CITY OF PORTLAND

BUILDING PERMIT

Job ID: 2012-01-3180-ALTR

has permission to remove & replace porch

# Plot Plan

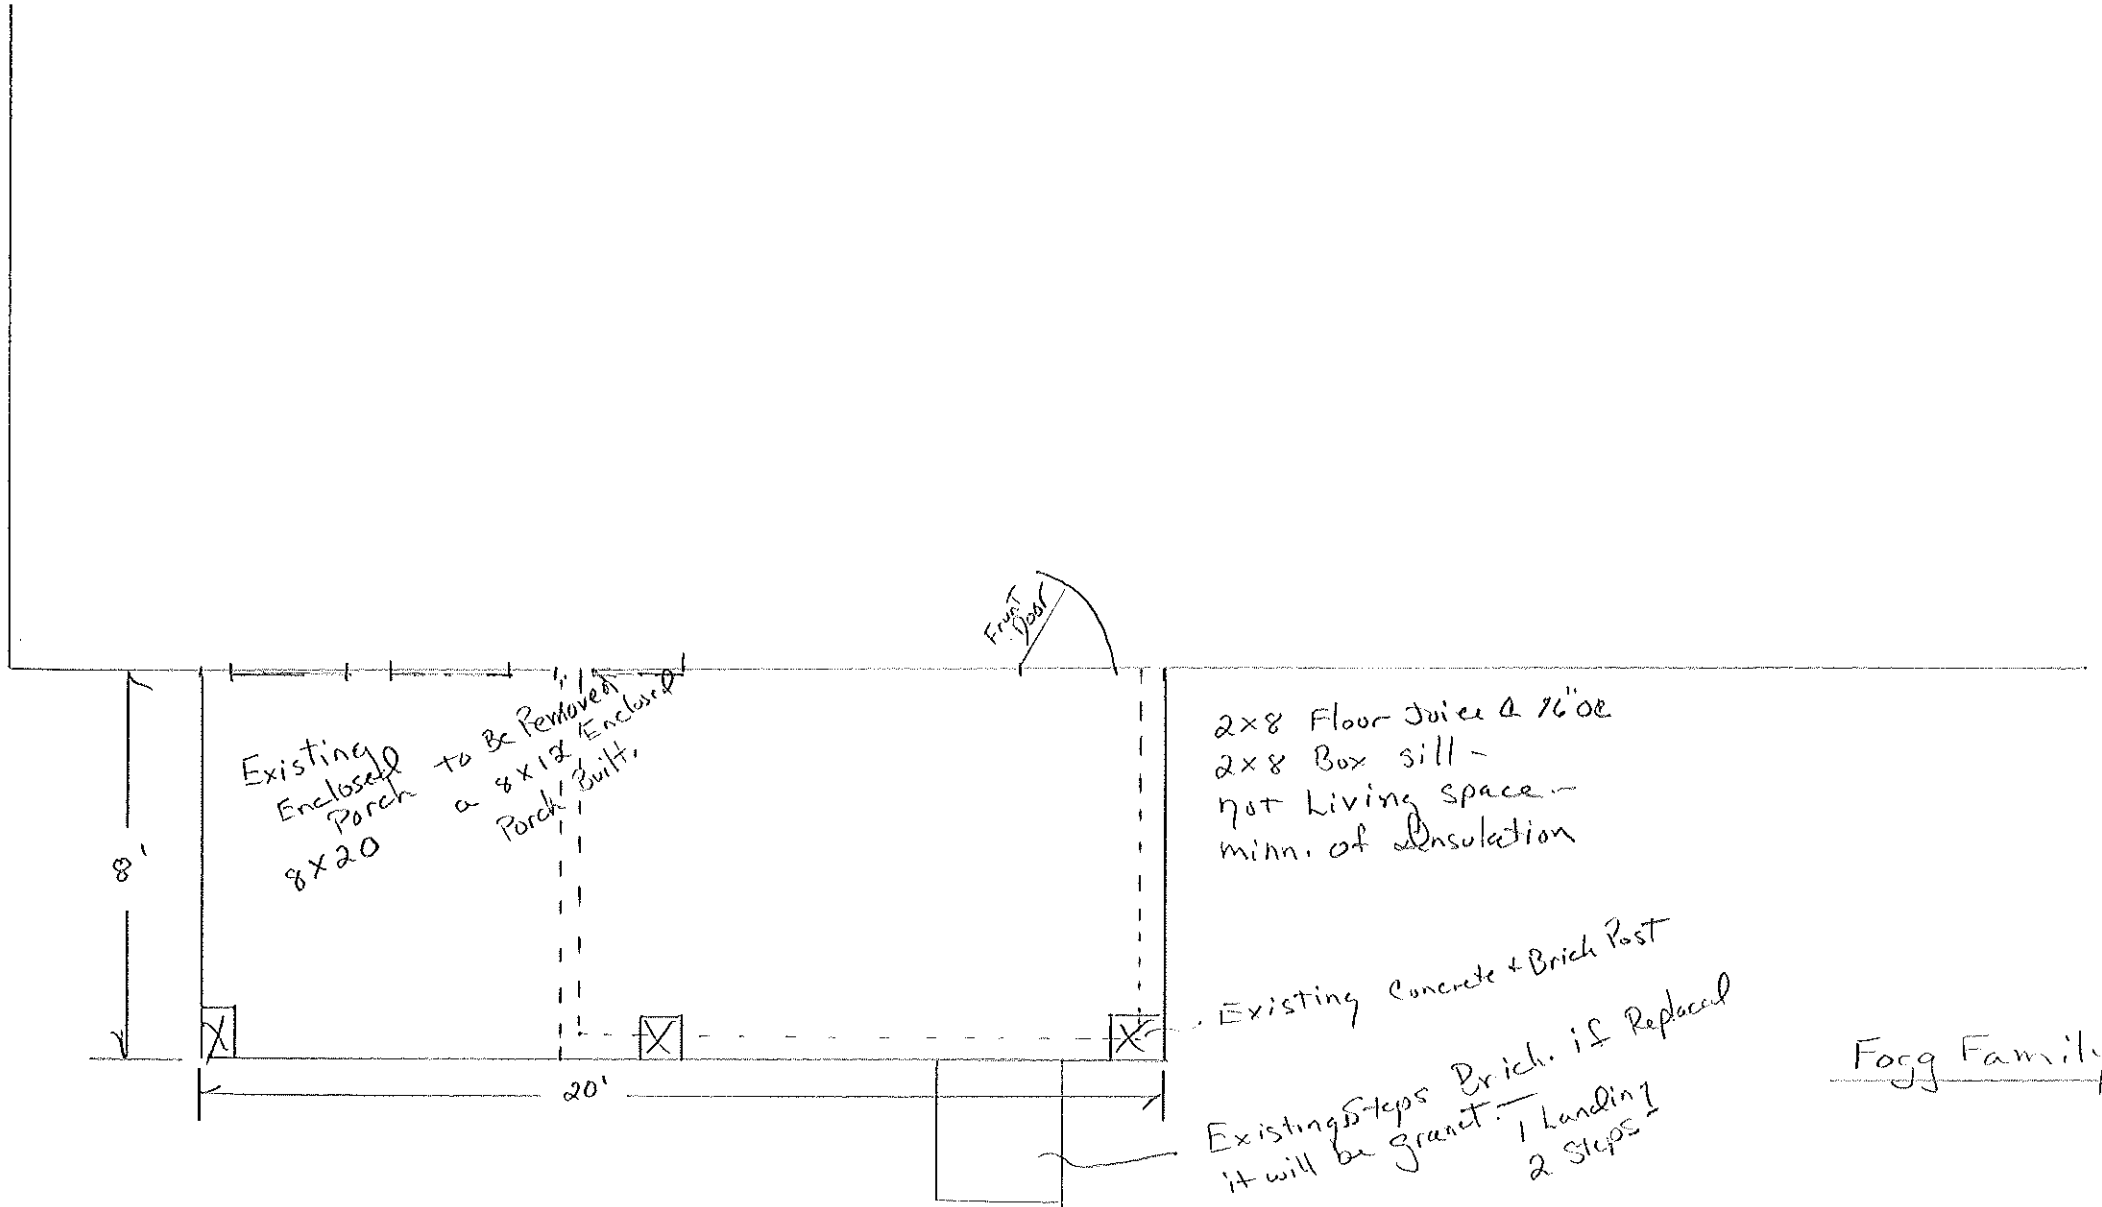
1. This permit is being approved on the basis of plans submitted. Any deviations shall require a separate approval before starting that work.
2. This property shall remain a single family dwelling. Any change of use shall require a separate permit application for review and approval.
3. The existing 20' x 8' enclosed porch is legally nonconforming as to the front setback. If you make it smaller, then you will not be able to enlarge it in the future.

Fogg Family  
28 Wall Street  
Portland Maine  
By C Vosmus -  
1/4" = 1'

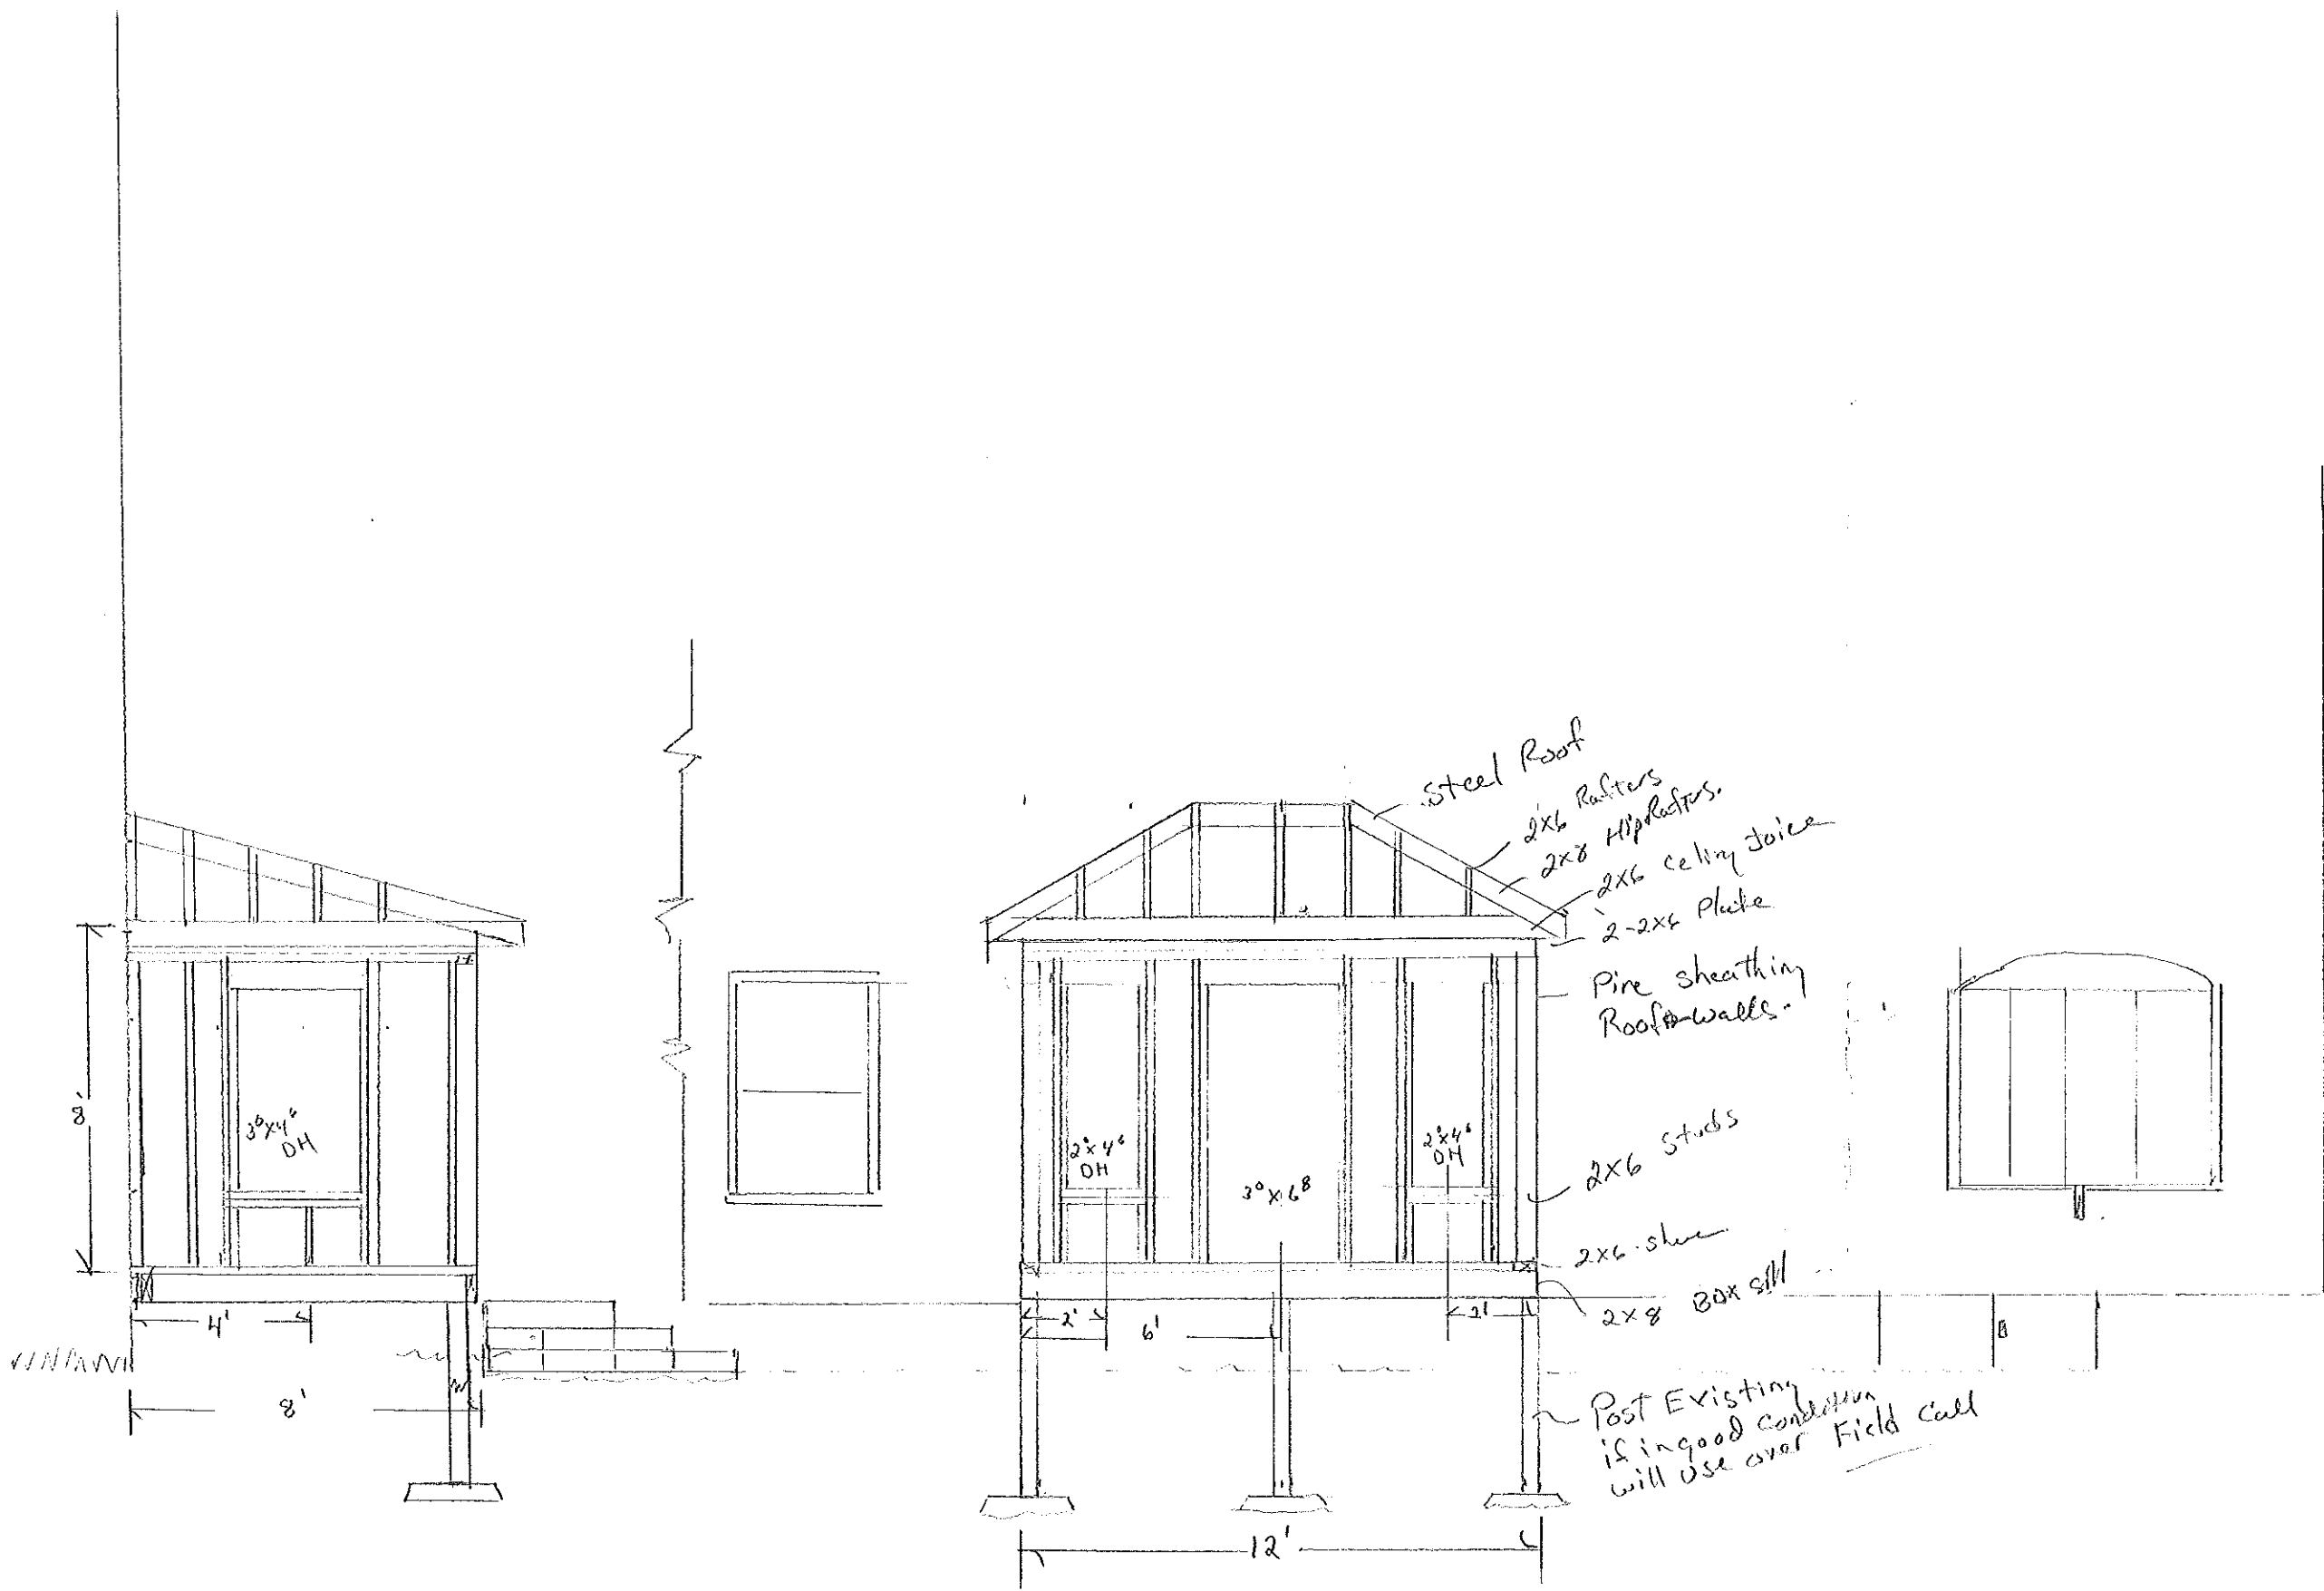
1. Separate permits are required for any electrical, plumbing, sprinkler, fire alarm HVAC systems, heating appliances, commercial hood exhaust systems and fuel tanks. Separate plans may need to be submitted for approval as a part of this process.
2. Application approval based upon information provided by applicant. Any deviation from approved plans requires separate review and approval prior to work.
3. The box sill must be 3-2"x8" minimum.
4. If the posts are replaced, they must be 4'-0" below grade.
